**Miss C Cripps, Brookenbee Cottage, Brook Lane, Rustington,
West Sussex. BN16 3JL. Tel: [REDACTED]**

Concerning planning application A/23/15/005.out

Title
HIGHWAY ACCESS PLAN

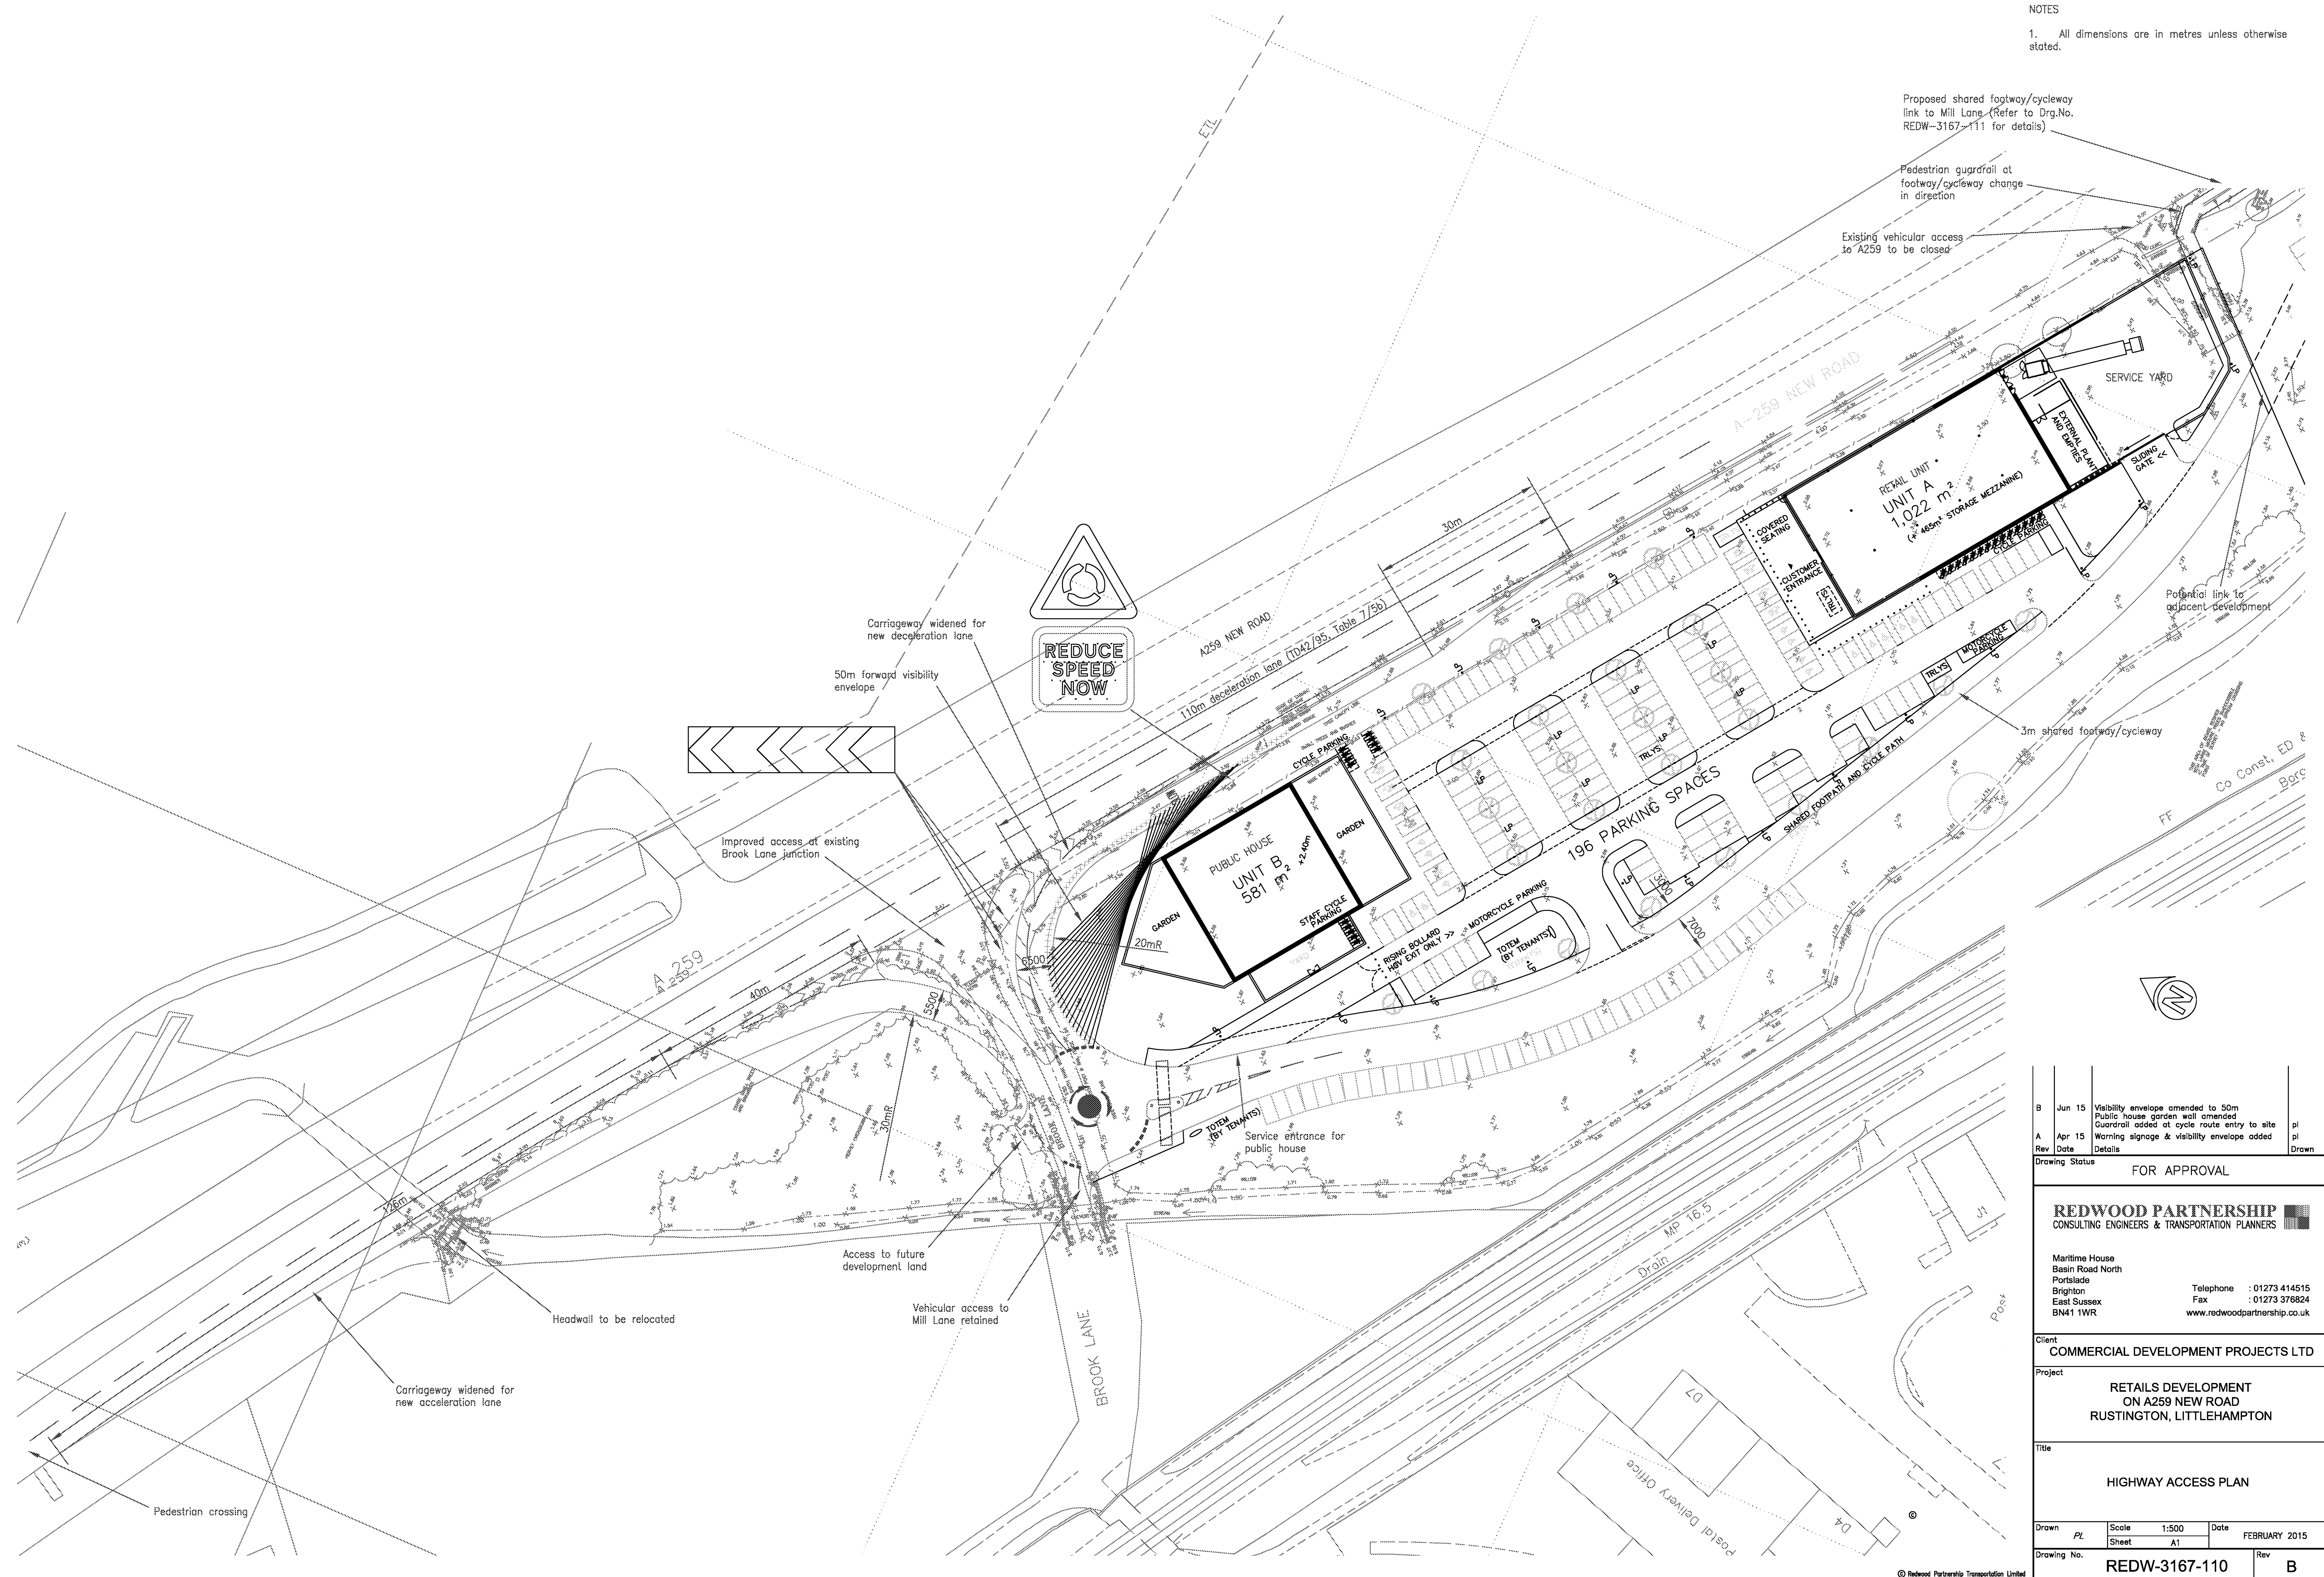
The proposed plans for a roundabout in Brook Lane, so close to the main carraigeway will make entering the lane dangerous. This is the only safe area for cars to overtake slow moving vehicles for many miles.

My interest in this proposal is as a resident of Brook Lane. The lane is fequently entered by large service vehicles. And the roundabout so close close to the main road would be restrictive to the free flow of the traffic on the main carraigeway.
